ENG-SF21026-R3-CDs.pdf Markup Summary

RD14
 SHEET: 19 OF 29

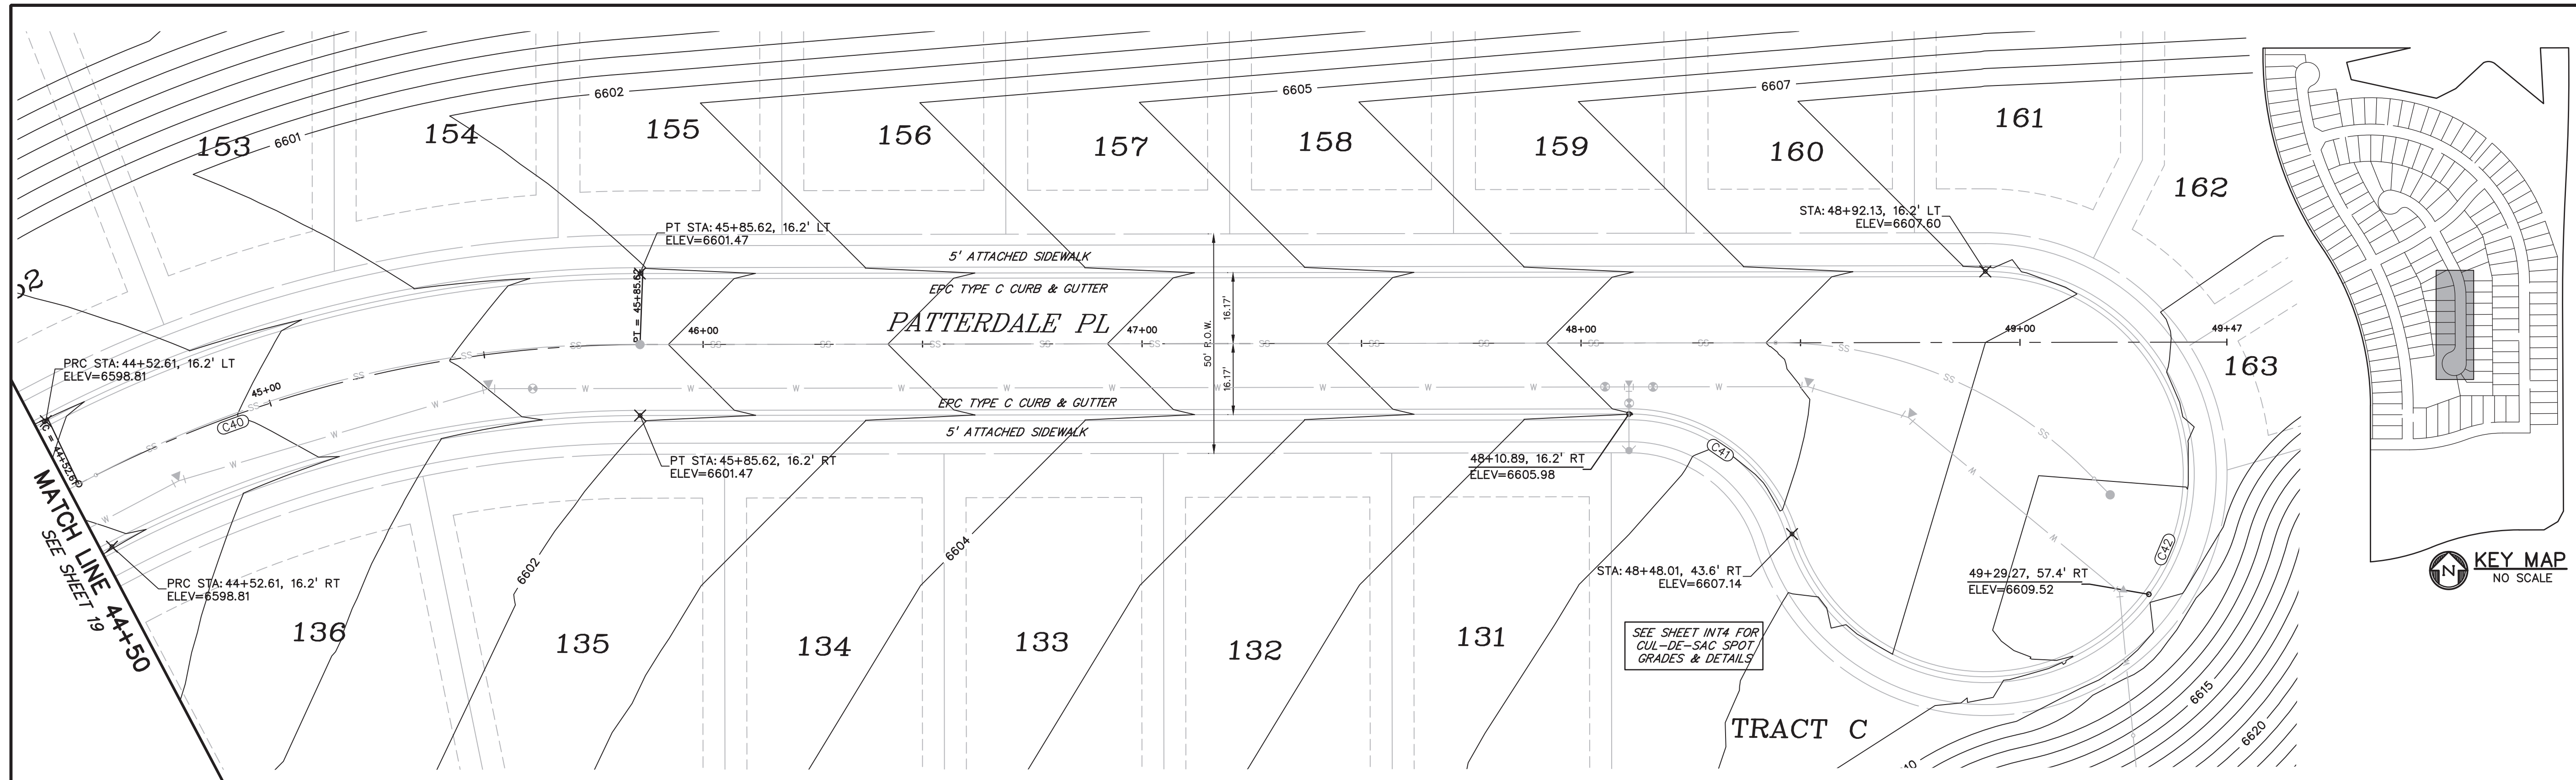
Per ECM 2.3.4.E Grade break difference must be less than 1% if no vertical curve provided

Show water and sanitary crossings in profile

Label storm crossing
